267 O'CONNOR STREET

SDRP REPORT (December 1, 2025)

APPENDIX_ SDRP RECOMENDATIONS (September 2, 2025)

- 1) **267 O'Connor Street** | Formal Review | Official Plan Amendment & Zoning By-law Amendment Application | Taggart Realty Management, Hobin Architecture, UNStudio, CSW Landscape Architects, Fotenn Planning + Design |

REDESIGN OVERVIEW_ TOWER

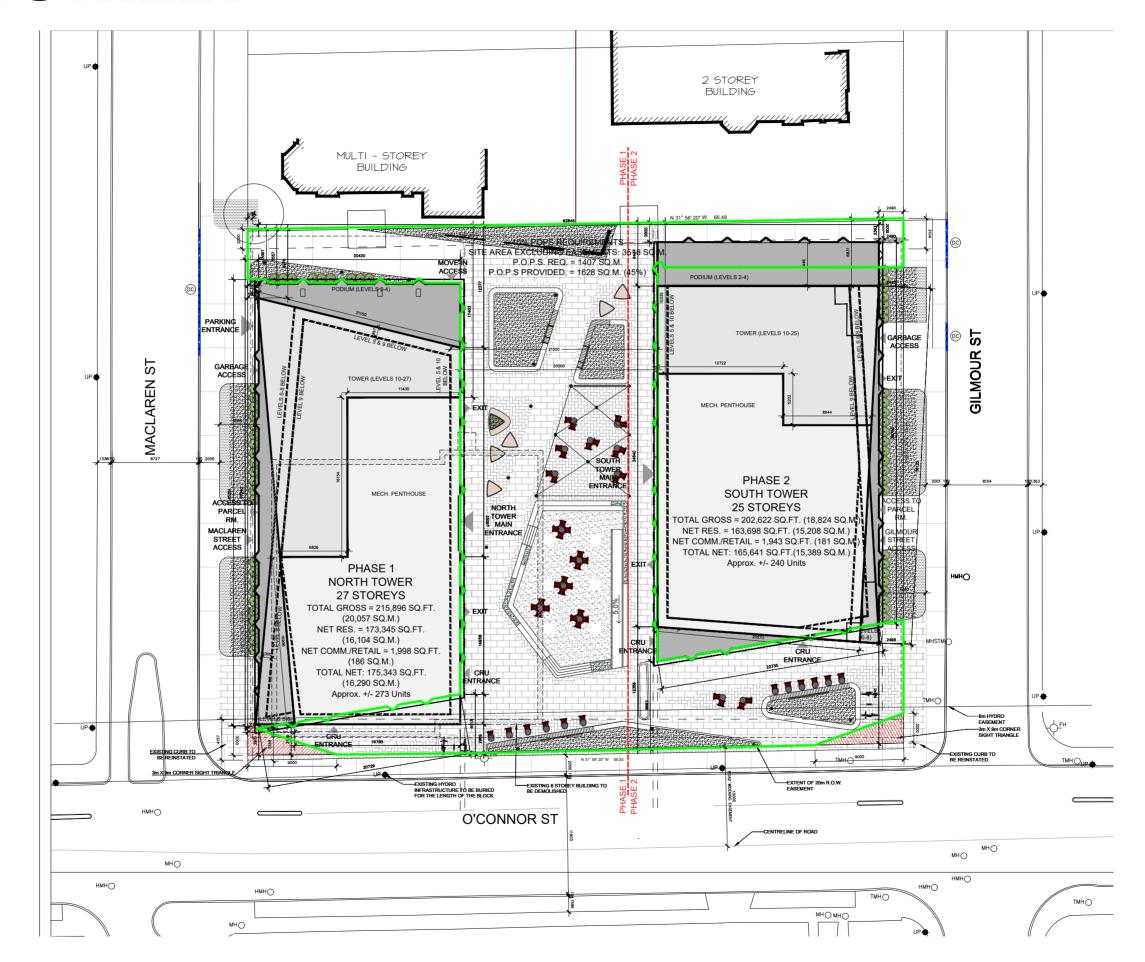
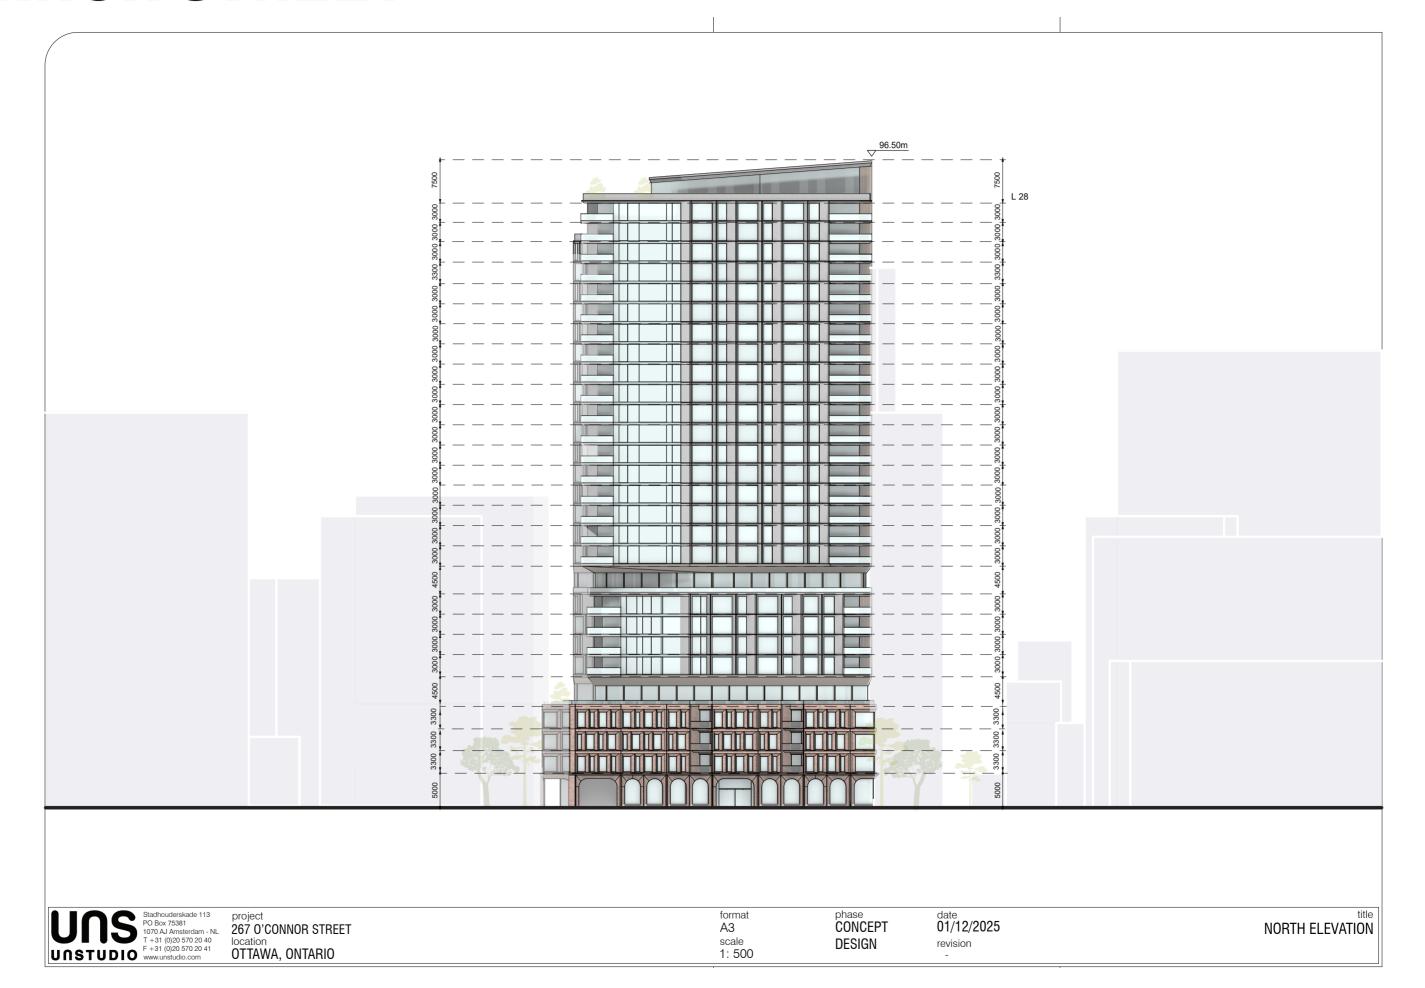
We have refined the design of the North and South towers to address the scale and visual impact of the long elevations along Gilmour and MacLaren. To break down the massing, a simplified facade module has been introduced towards the eastern end of the towers. This approach creates a more dynamic and visually engaging composition, reducing the overall scale and enhancing the architectural rhythm of the facades.

- The Panel notes that the POPS access to Gilmour Street feels pinched and recommends the setback be increased to improve the visibility and porosity of the POPS.

- The Panel observes that the elevated planters may limit accessibility and reduce the flexibility of the POPS.
- The Panel notes that daylight in the POPS will be limited in winter but that the wind conditions are reasonable.

To improve the relationship between the development and its surrounding streetscape, the south tower's setback along the east property line on level 1 has been increased. This adjustment creates a more generous and inviting connection between Gilmour and Maclaren streets, enhancing pedestrian flow and accessibility. By increasing the setback, the design opens up the space, allowing for better integration with the public realm and fostering a stronger sense of connectivity between the two streets. This change not only improves the functionality of the site but also contributes to a more welcoming and safe urban environment.

The landscape strategy for the POPS has been re-imagined to enhance functionality and circulation. One of the key changes involves relocating the elevated gathering feature closer to O'Connor Street. This new placement creates a more prominent and accessible focal point for public interaction and activity. Additionally, the overall flow and circulation within the space have been significantly improved by refining the locations and angles of planters and pathways. These adjustments ensure that the space feels more intuitive and user-friendly, encouraging movement and engagement while maintaining a sense of openness and cohesion. The redesign prioritizes both functionality and design, making the POPS a vibrant and inviting area for the residents and community.

VIEWS_N/W OCONNOR CORNER **01**

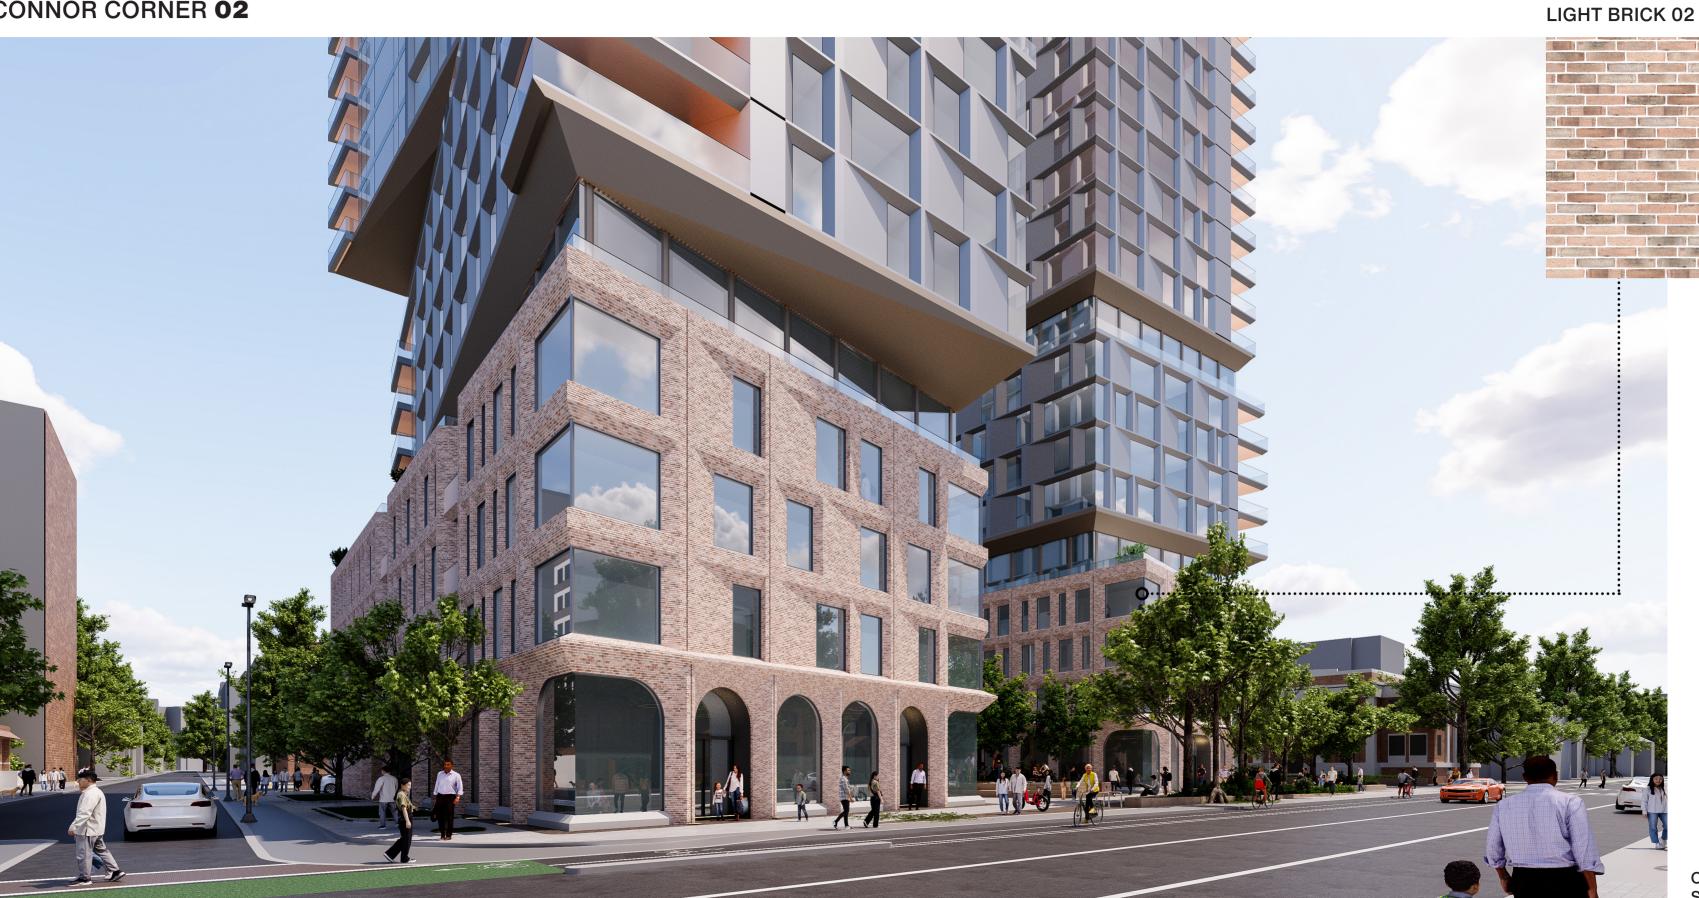
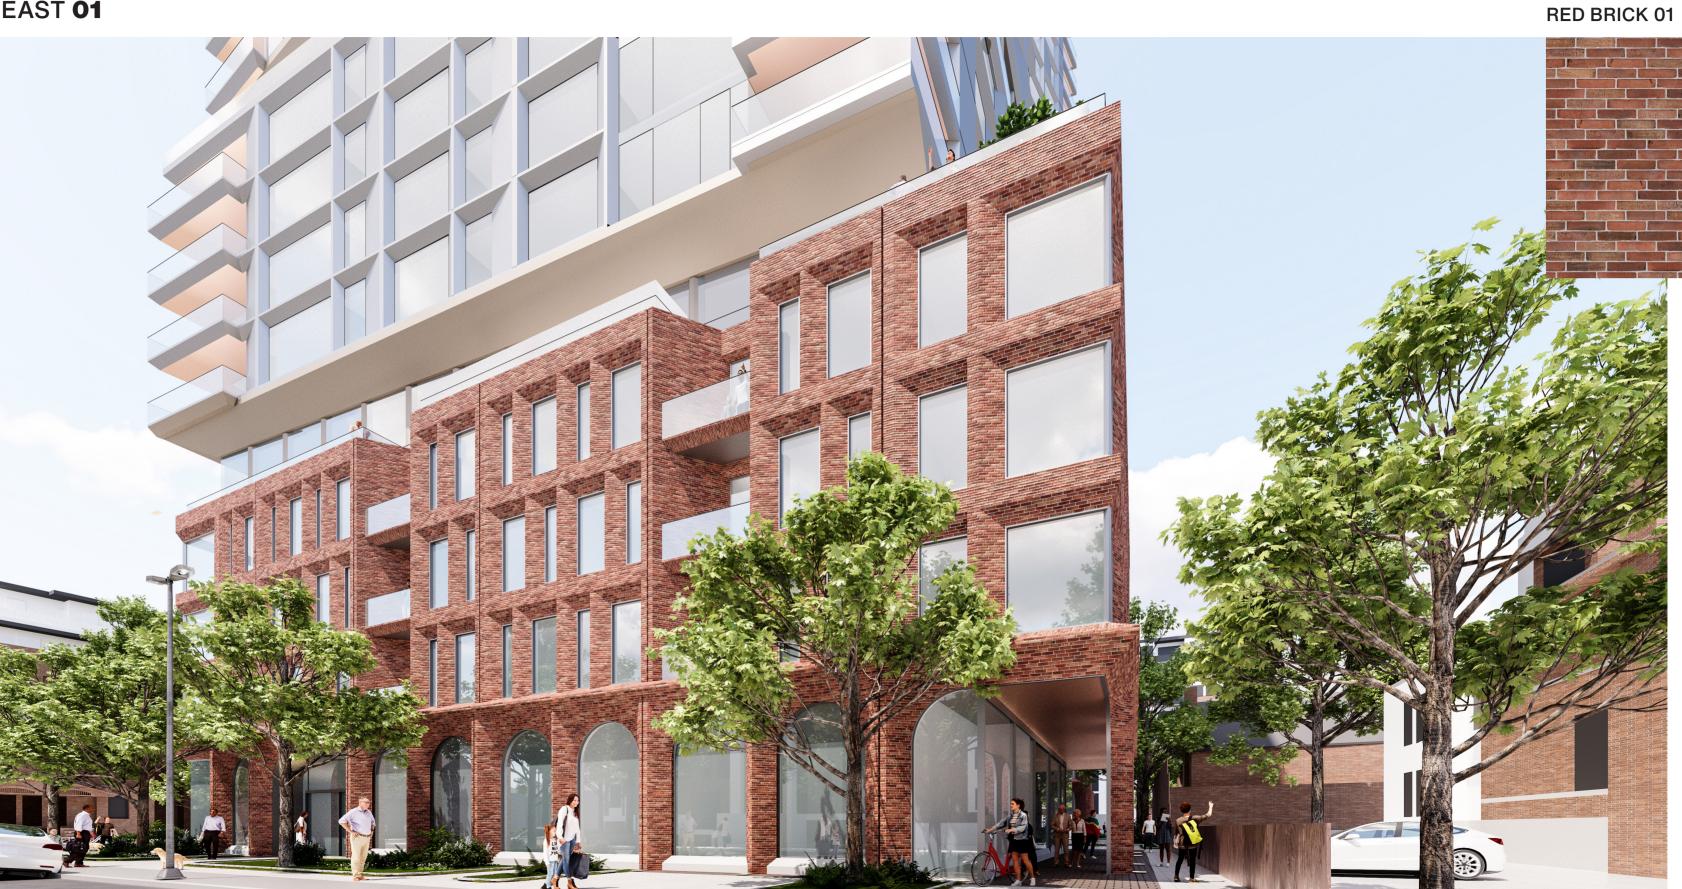
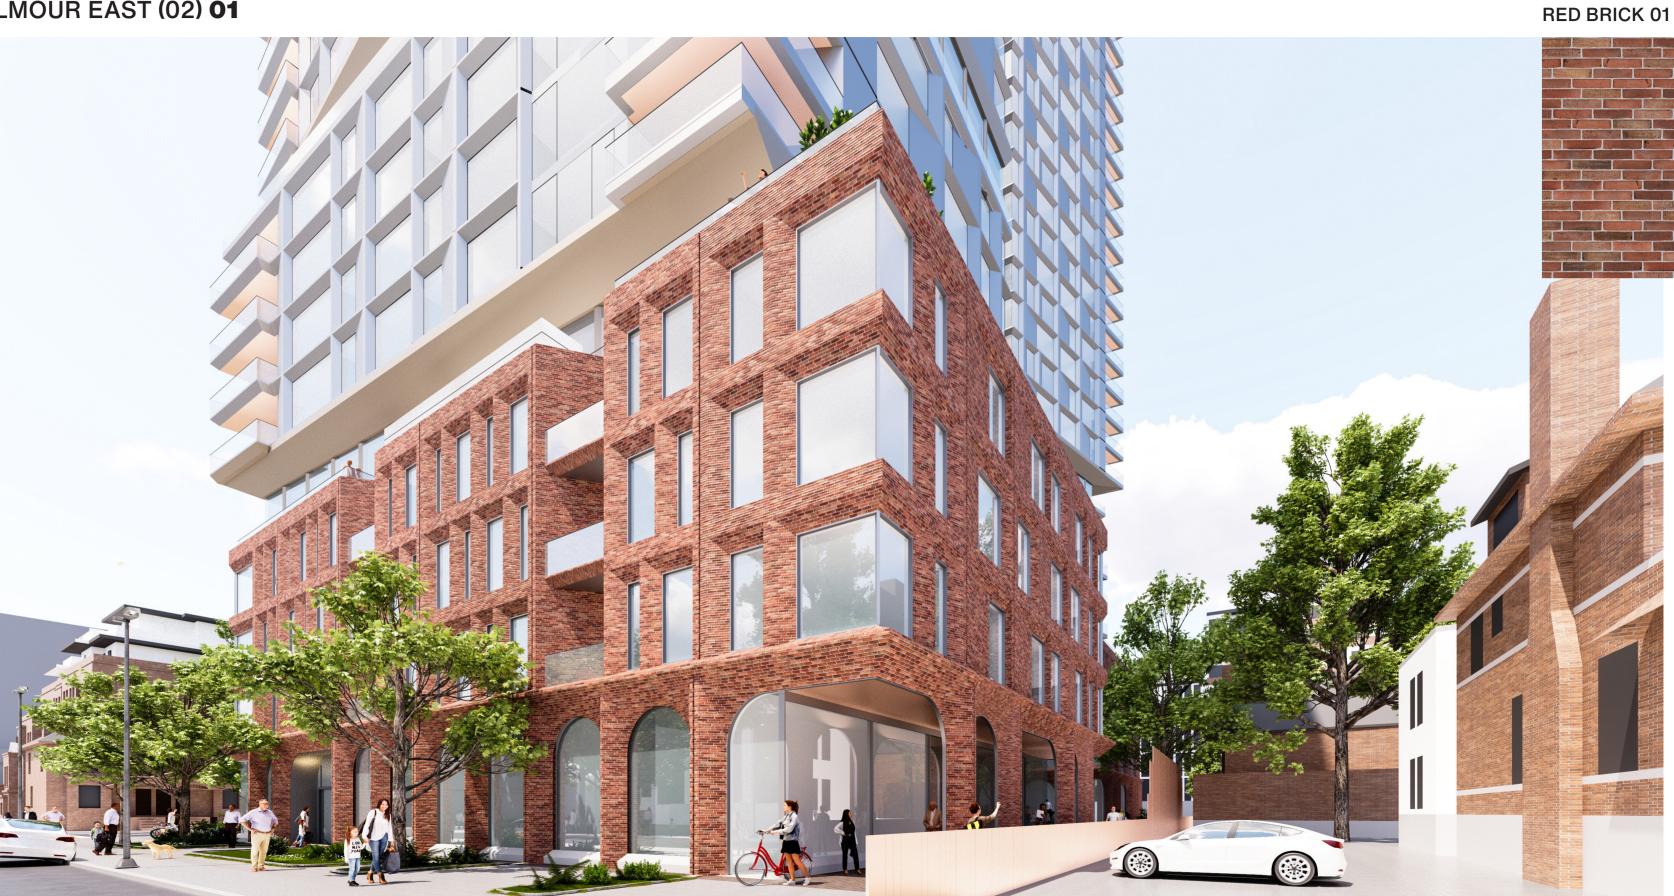
- The Panel recommends continuing the red brick to grade to give the base more heft and to strengthen the visual transition to the tower.
- The Panel recommends further refinement of the podium façade geometry to reflect the internal functions of the building.
- The Panel recommends studying the geometry of the podium soffit and cantilever. A simpler, orthogonal soffit treatment may be more consistent with the tower expression and create a stronger visual hierarchy.
- The Panel recommends providing more clarity in future renderings along Gilmour Street and Maclaren Street to better understand the contextual relationships to the neighbouring properties.
- The Panel encourages further exploration of the fenestration pattern to ensure that there is indoor/outdoor engagement between the building and the POPS.

- The Panel recommends making the tower top more cohesive, either with a continuous slope or by extending the cladding as a frame.
- The Panel notes that screening details for the mechanical components on the top of the towers are needed and should be integrated into the tower tops.

- The Panel recommends introducing articulation, such as balconies or recesses, to break up the north-facing façade, which appears too flat.
- The Panel recommends further exploration of the underside materials of the balconies so that their appearance from the public realm contributes positively to the architectural aesthetic.

The Heritage Podium has taken into consideration the recommendation from the Panel by extending the red masonry to the lower level,. This design implementation not only reinforces the architectural connection to the site's historical context but also creates a sense of continuity and grounding for the podium. By integrating the red masonry throughout, the podium establishes a strong visual identity that ties it to the surrounding urban fabric while respecting the heritage elements of the site. This approach ensures that the podium serves as a harmonious base for the overall development, blending modern design with historical character of the neighborhood.

The roof and canopy have also been improved to create a larger and more functional exterior space. The sloping canopy design not only provides a seamless transition between the north and south facades but also adds to the overall form. This design element enhances the usability of the roof area while contributing to the building's architectural identity.

We have also improved the design and articulation of the balconies, which now feature a warm-toned stone or metal material on their undersides and inner walls. This material choice creates a sense of warmth in materiality while also establishing a smooth visual transition to the canopy of the roof. The careful detailing of the balconies adds depth and texture to the facade, enhancing the overall aesthetic and creating a cohesive design language that ties together the various elements of the towers. These refinements ensure that the towers not only function effectively but also contribute to a distinctive architectural design.
